**CITY OF ALBUQUERQUE
PLANNING DEPARTMENT
February 16, 2004
DRB Comments**

PROJECT # 1003931

RE: Tract A, Atrisco Business Park/sketch

DEVELOPMENT REVIEW BOARD--SPEED MEMO

SKETCH PLAT
PROPOSED TRACTS A-1 AND A-2,
ATRISCO BUSINESS PARK, UNIT 1

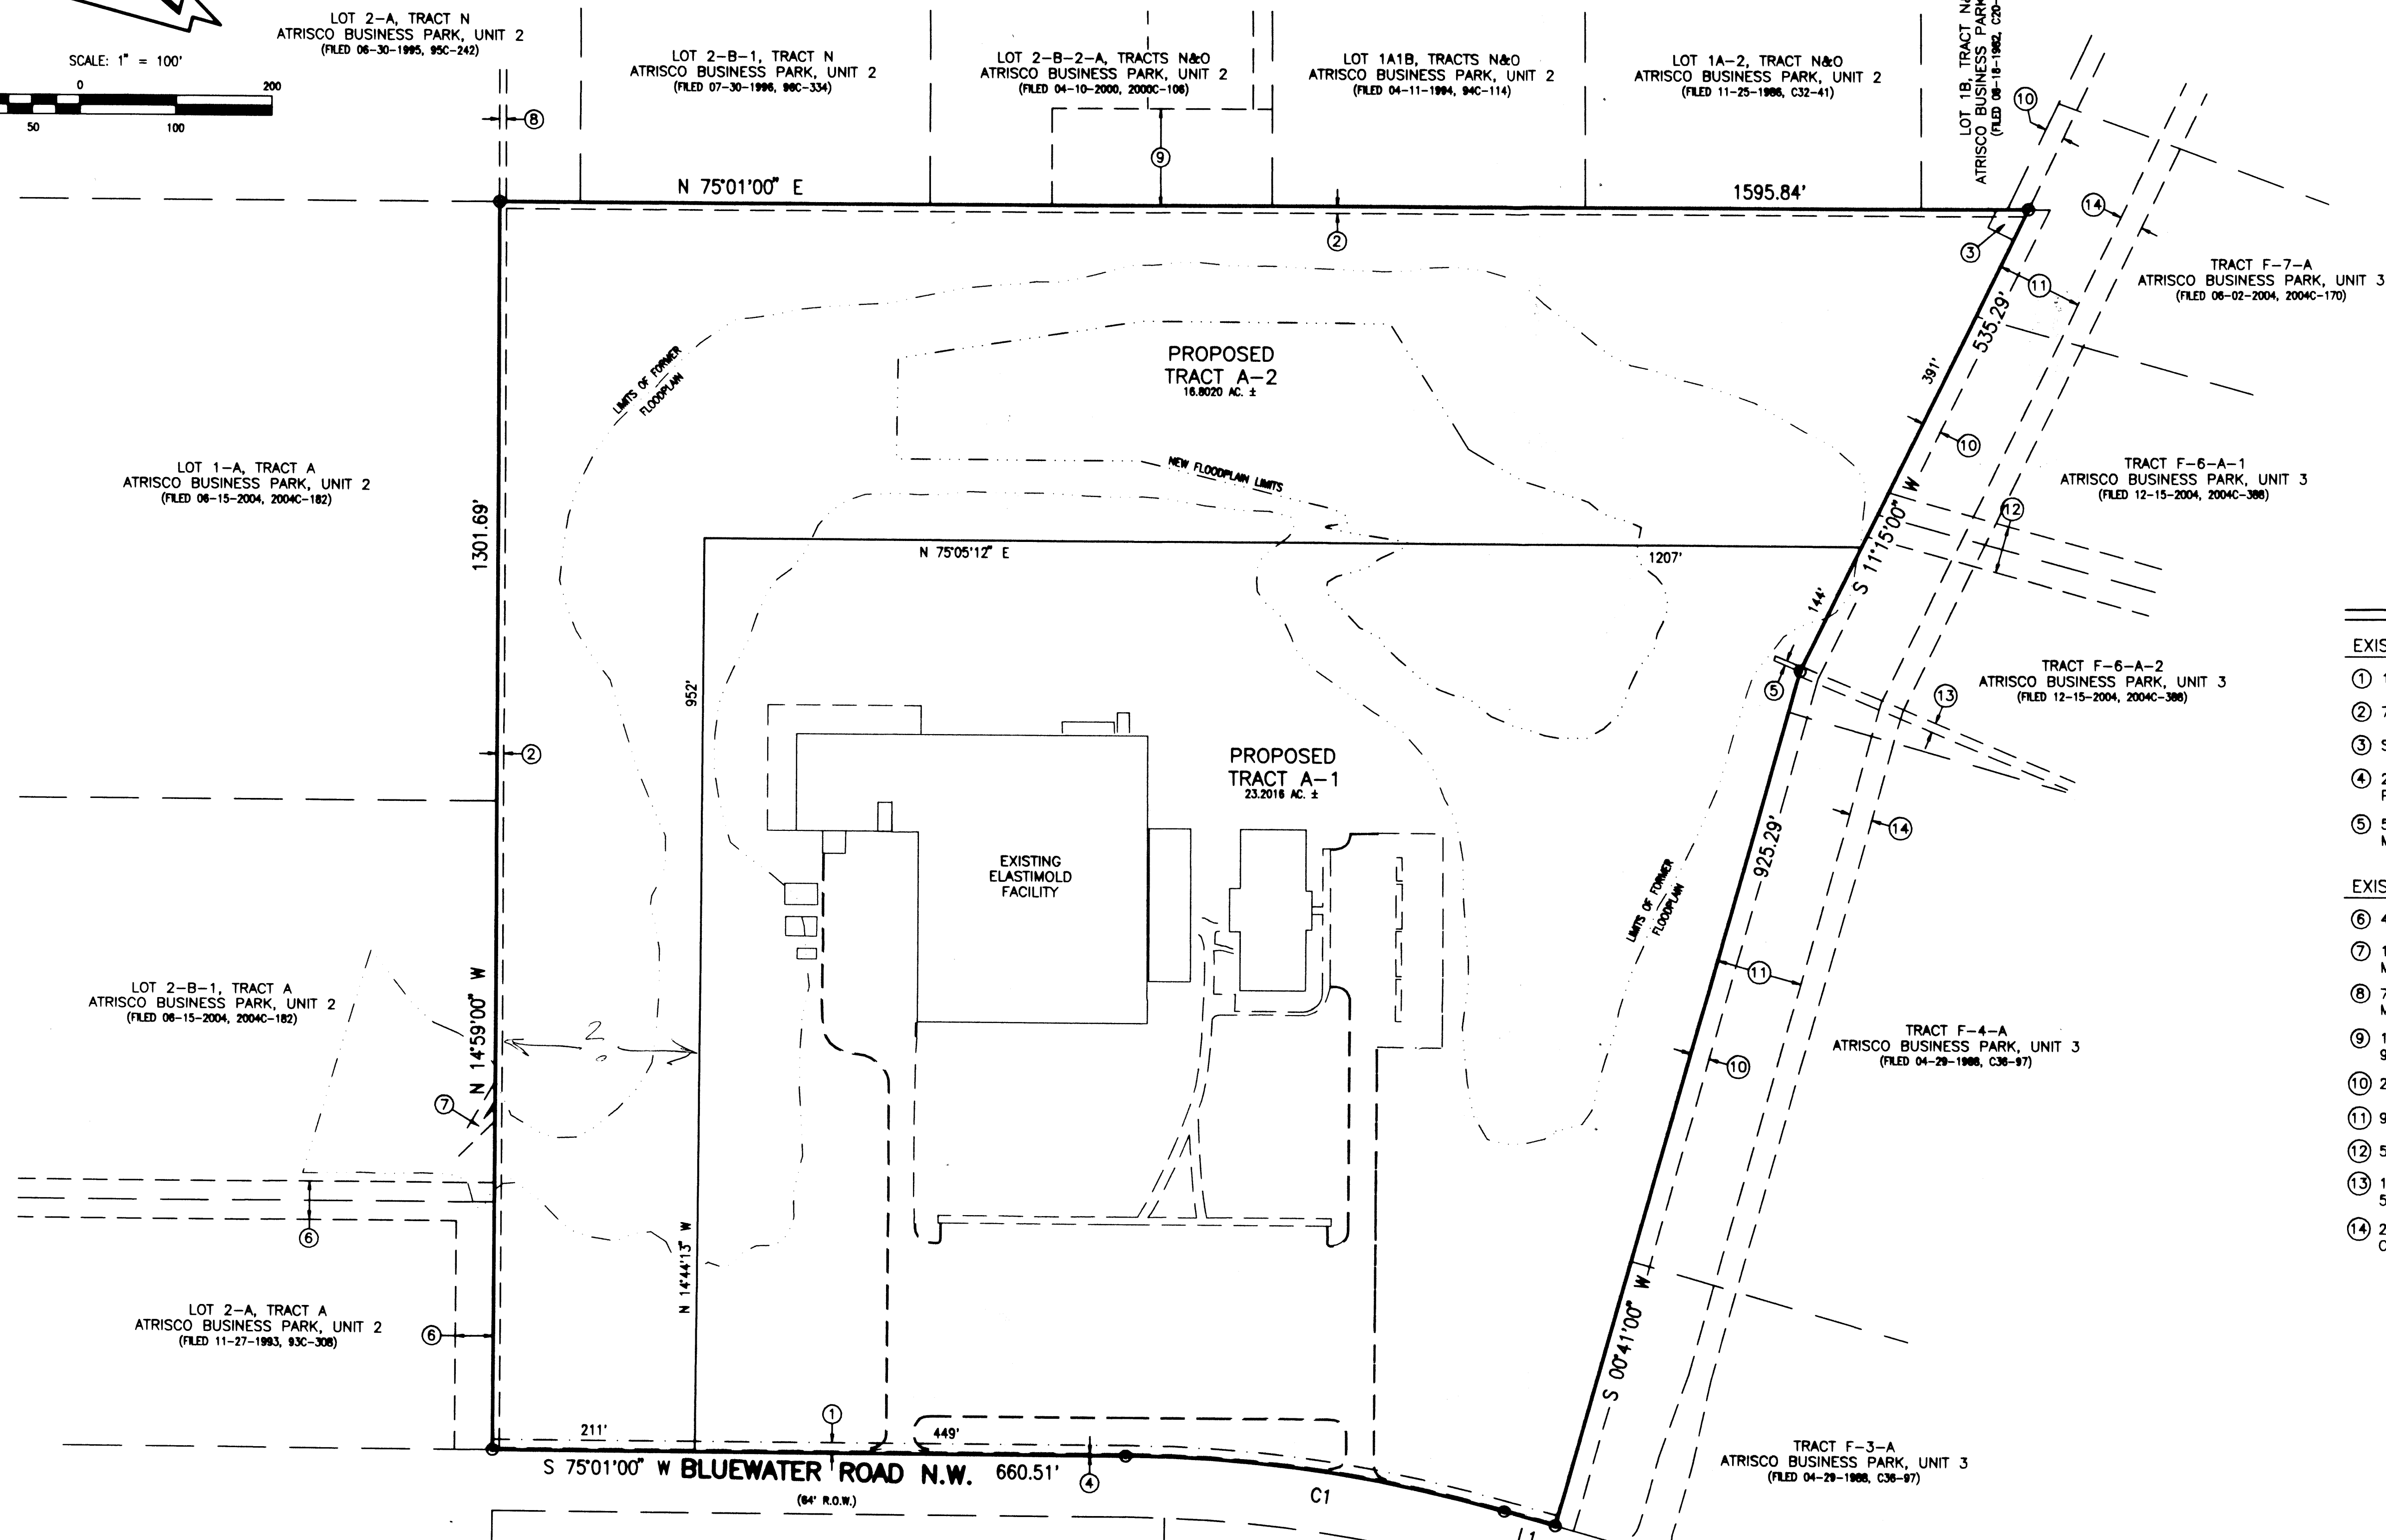
Where is the existing sanitary sewer service line and connection point for the existing development? Private service line easements will be required for this line.
